CITY OF ALBUQUERQUE

**Re: Signal Avenue Condo Drainage report
Engineer's Stamp Date 2-12-14 (C20D070)**

APPENDIX D WORKMAP

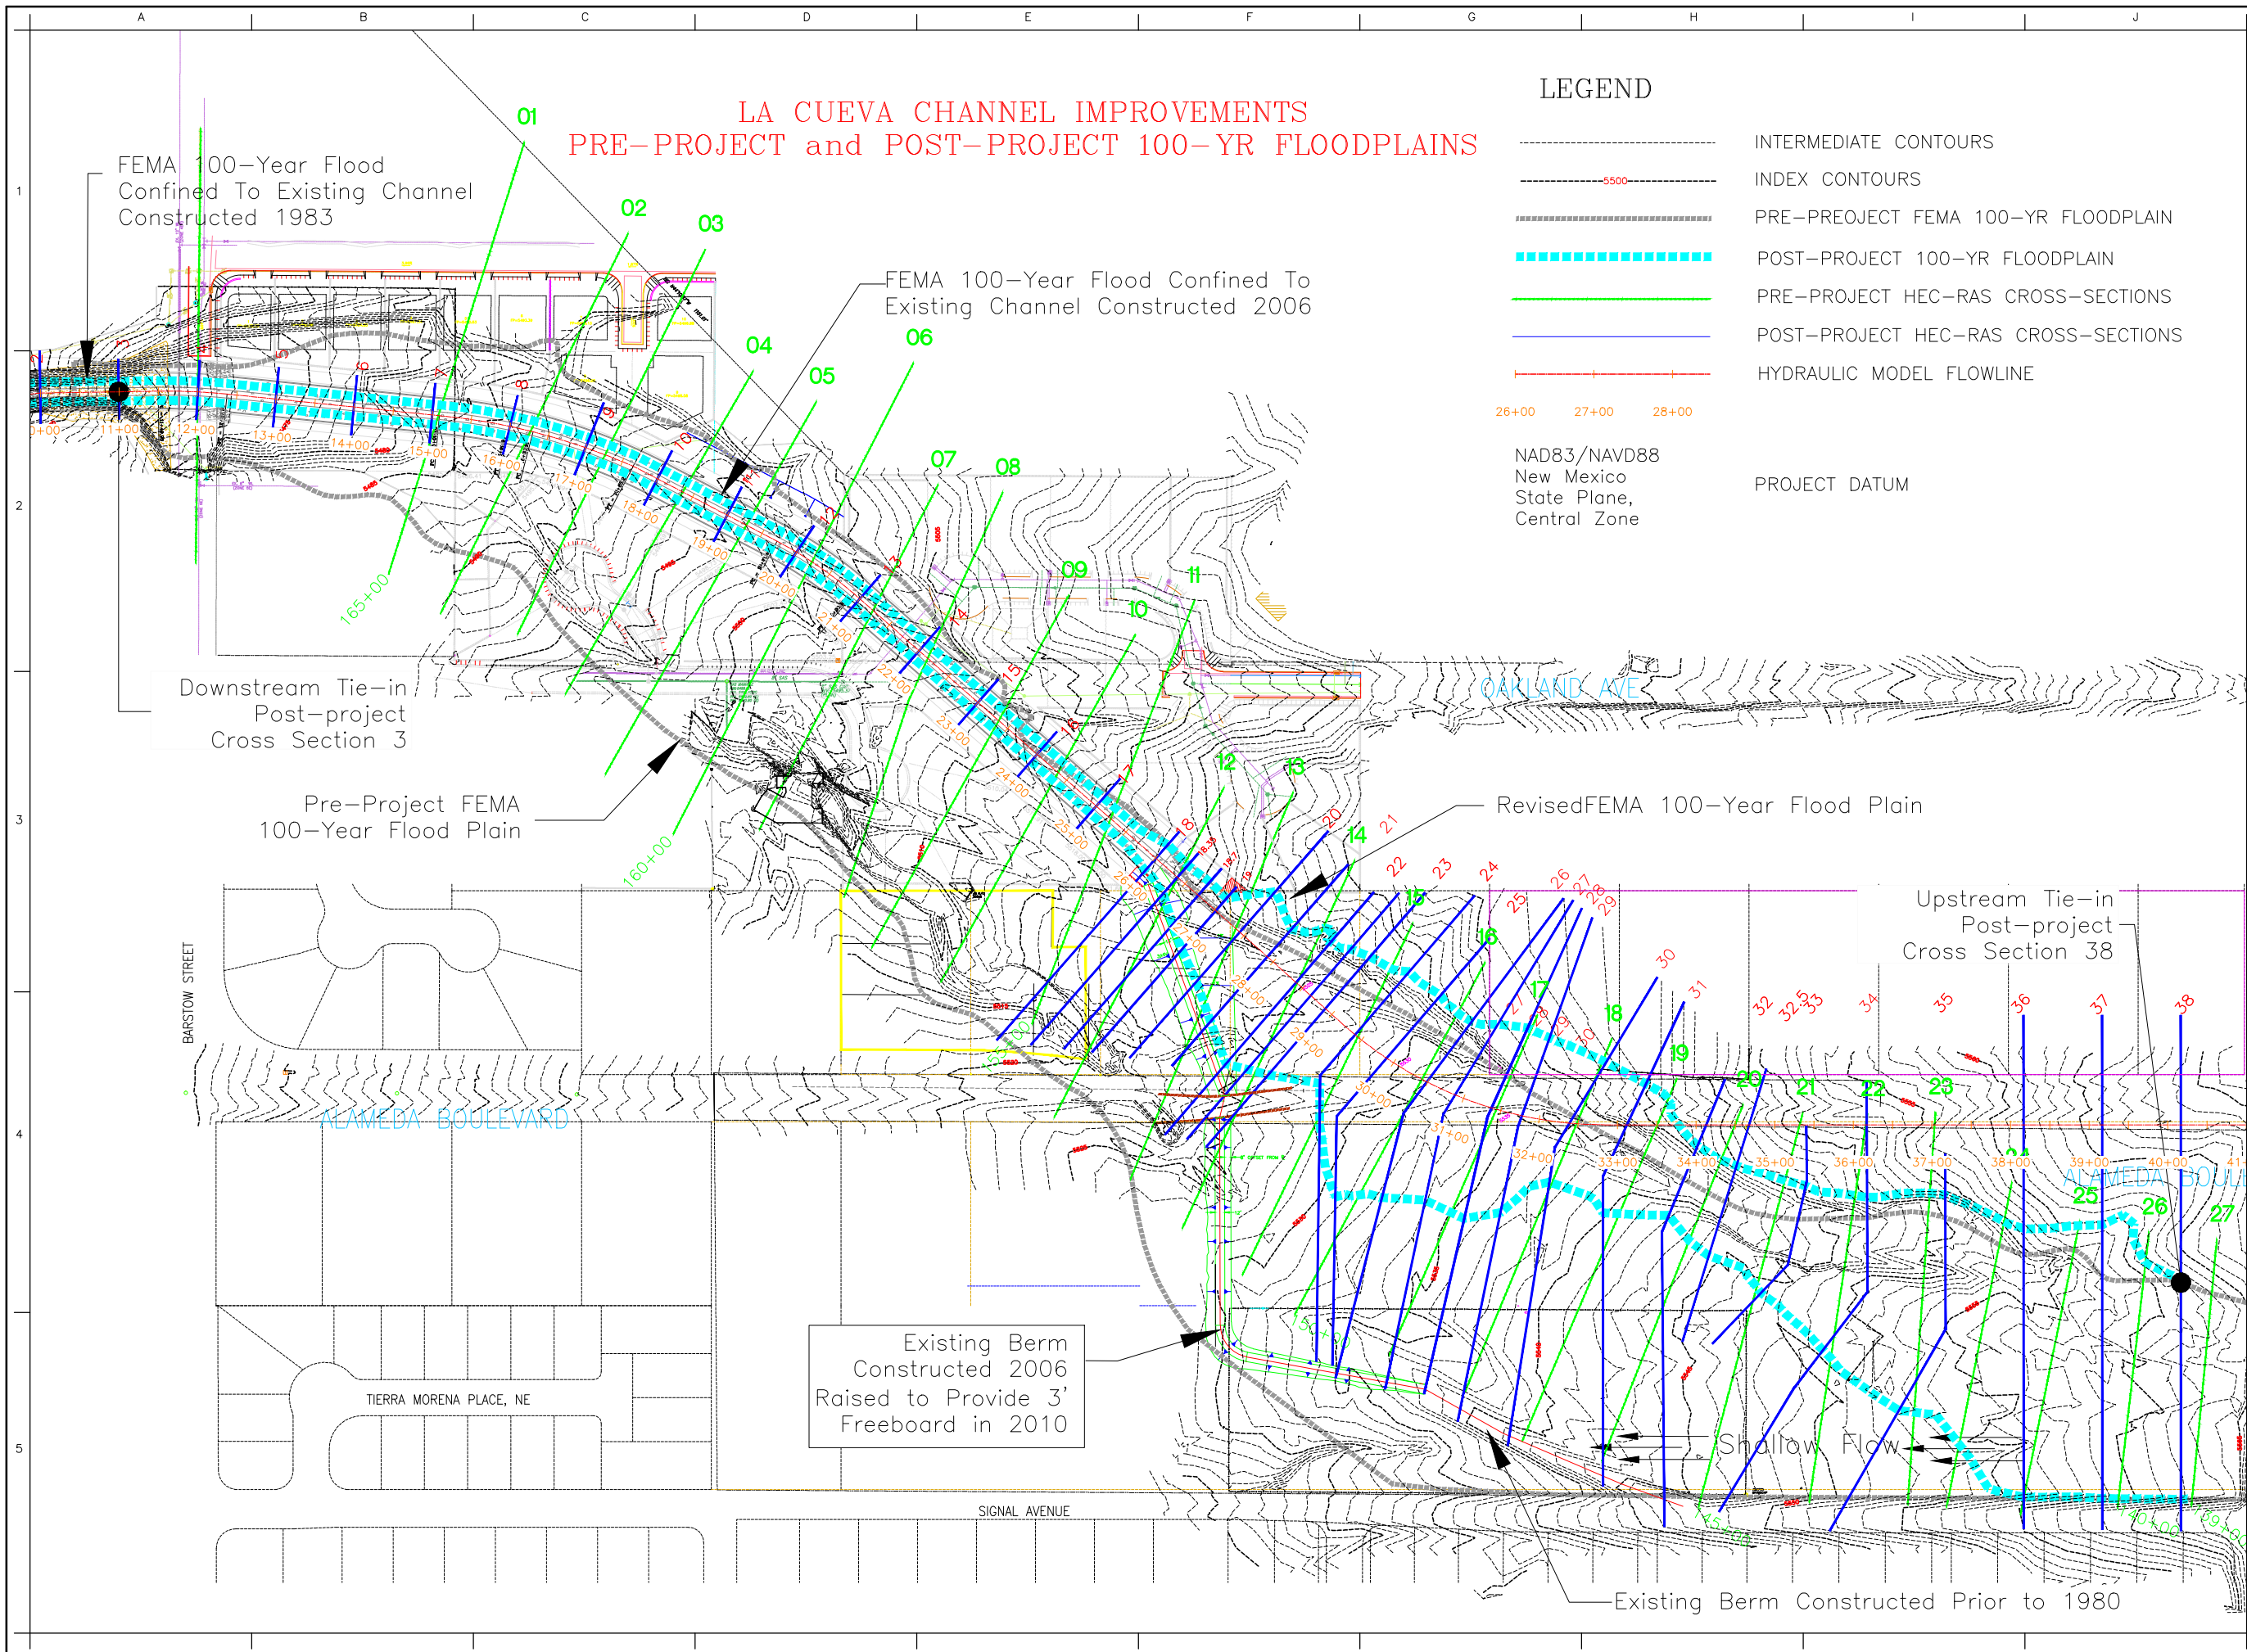
Based upon the information provided in your submittal received 2-12-14 and recent site visits, the above referenced report cannot be approved because it appears the southern branch of the La Cueva Arroyo runs through this site.

1. Changing the proposed development plan to stay on the south side of the southern branch of the arroyo.
2. If your client wishes to proceed with development of the site in the same location as proposed:
 - a. Construct an armored berm with scour protection to prevent water from entering the southern branch of the arroyo on lots 17 and 18 to begin on Lot 17 at/near Ventura Blvd.
 - b. Build a scour/flood wall on the north and east sides of the development.
 - c. Grade on Lot 18 so localized flows can pass between the armored berm mentioned in comment a above and the scour/ flood wall in comment b above.
 - d. The design would not alter the relatively new mapped floodplain (LOMR).
 - e. Construction on adjacent property requires written approval from those property owners.
